Ribble Valley Borough Council  
Housing & Development Control

Your ref: 3/2023/1026  
Our ref: D3.2023.1026  
Date: 26<sup>th</sup> February 2024

Application no: **3/2023/1026**

Address: **23 Pendleton Road Wiswell BB7 9DD**

SHEET: EXISTING AND PROPOSED
SITE PLAN

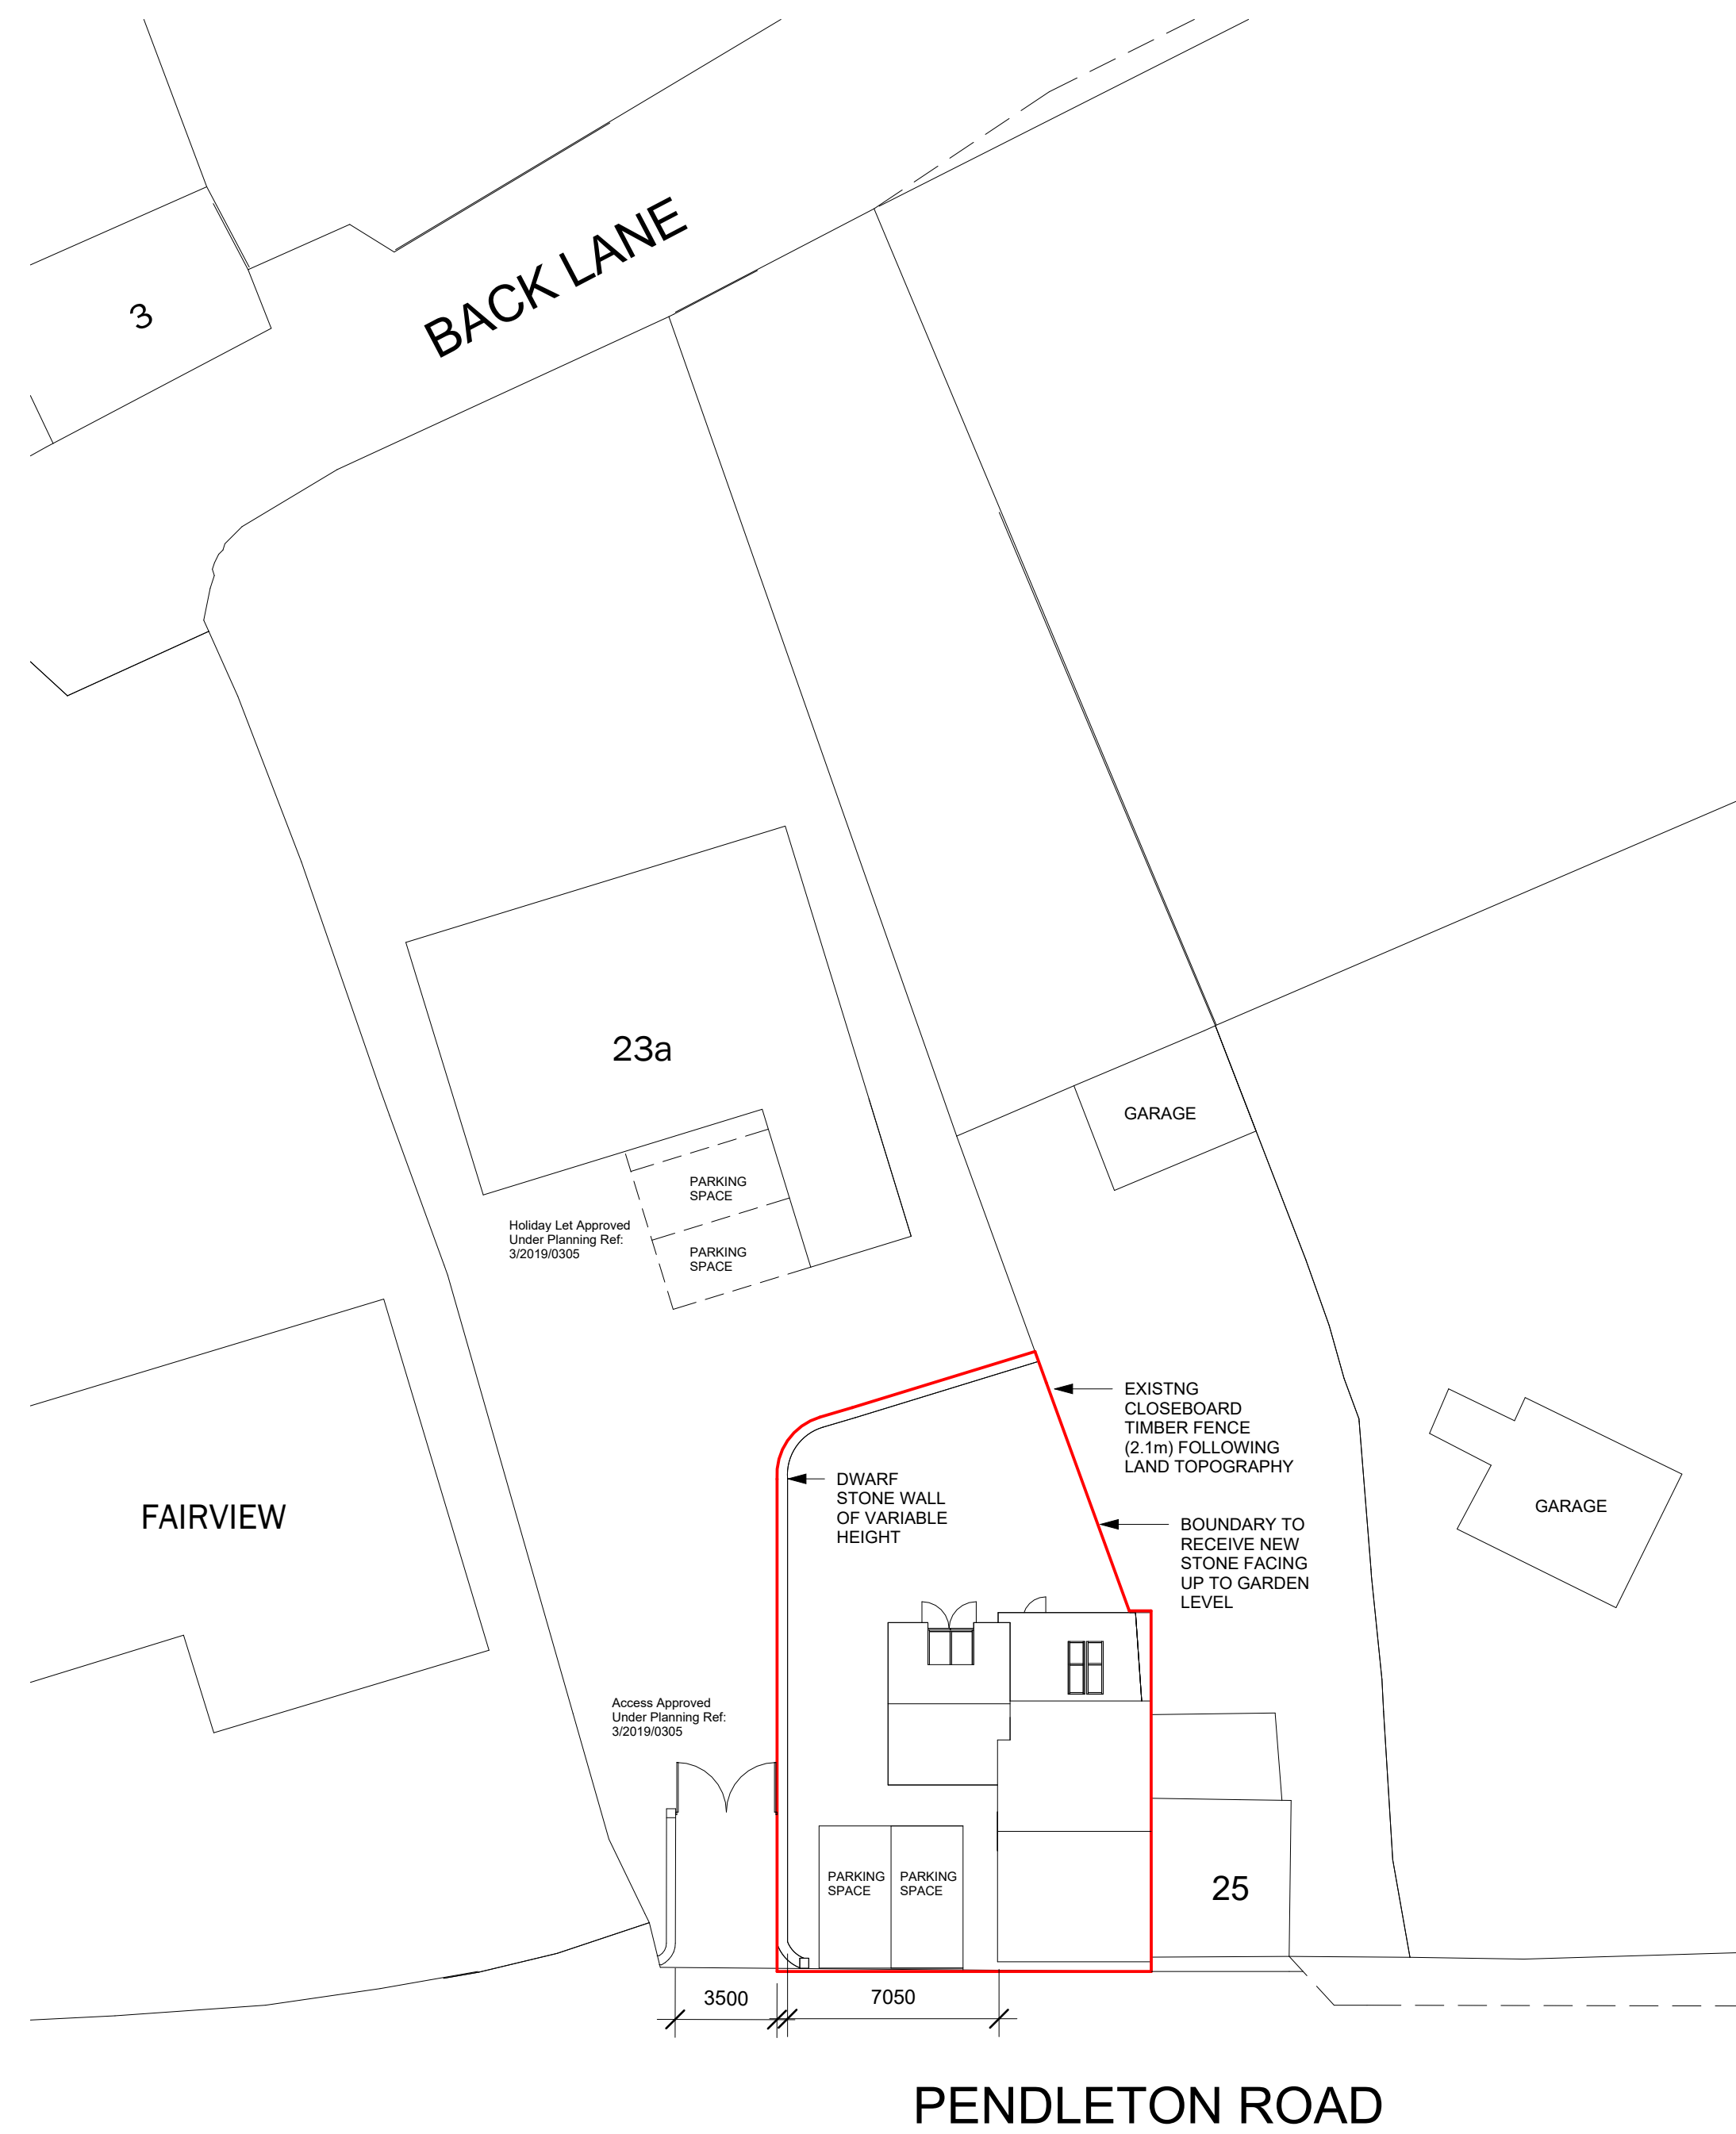
The LHA have reviewed Peter Hitchen drawing number A2.3 titled "Existing and Proposed Site Plan" and the supporting information and note that the access which was approved under application reference 3/2019/0305 will now be used to serve the holiday cottage only. Previously, the access was shared between this dwelling, the current application relates to and the holiday cottage with them being within the same ownership. However, since then a third party owns the holiday cottage and so a separate access and parking area has been proposed for the dwelling.

Unfortunately, given that a parking area for the dwelling has been provided which fronts Pendleton Road, the access which has been approved under application reference 3/2019/0305 has been reduced in width from 4m to 3.5m. The proposed parking area for the dwelling also appears to conflict with the visibility splay to the west of the holiday let access.

Given these concerns, the LHA would prefer that the already approved parking and access arrangements for the dwelling are utilised rather than a new area is created which encroaches upon the already approved access. However, should this not be possible the LHA will accept the creation of a new parking area for the dwelling. This is because on balance the LHA are unable to accept any on-street parking in this location due to

Pendleton Road being narrow. Therefore, even though the visibility splays for the access serving the holiday let are obstructed, not providing any parking facilities for the dwelling would have more of a detrimental impact upon highway safety given the single tracked nature of the road. Therefore, the LHA have no objection to the proposal subject to conditions.

These conditions include requiring a boundary treatment plan to be submitted prior to commencement. The LHA require the stone wall separating the holiday cottage and the dwelling to be partially removed. This should be from where the parking area starts to where the gated access is located. The LHA require the removal of the wall in this area to ensure that the visibility splays for the holiday let access are not obstructed further and so the area should be kept clear.

2. No part of the development hereby permitted shall be occupied until such time as the access arrangements shown on Peter Hitchen drawing number A2.3 have been implemented in full.

5. Notwithstanding the submitted details, commencement, details of the proposed boundary walling and fencing shall have been submitted to and approved by the Local Planning Authority, in consultation with the Local Highway Authority. The development shall be carried out in strict accordance with the approved details.

6. The development hereby permitted shall not be occupied until such time as the parking and turning facilities have been implemented in accordance with Peter Hitchen drawing number A2.3. Thereafter the onsite parking provision shall be so maintained in perpetuity.
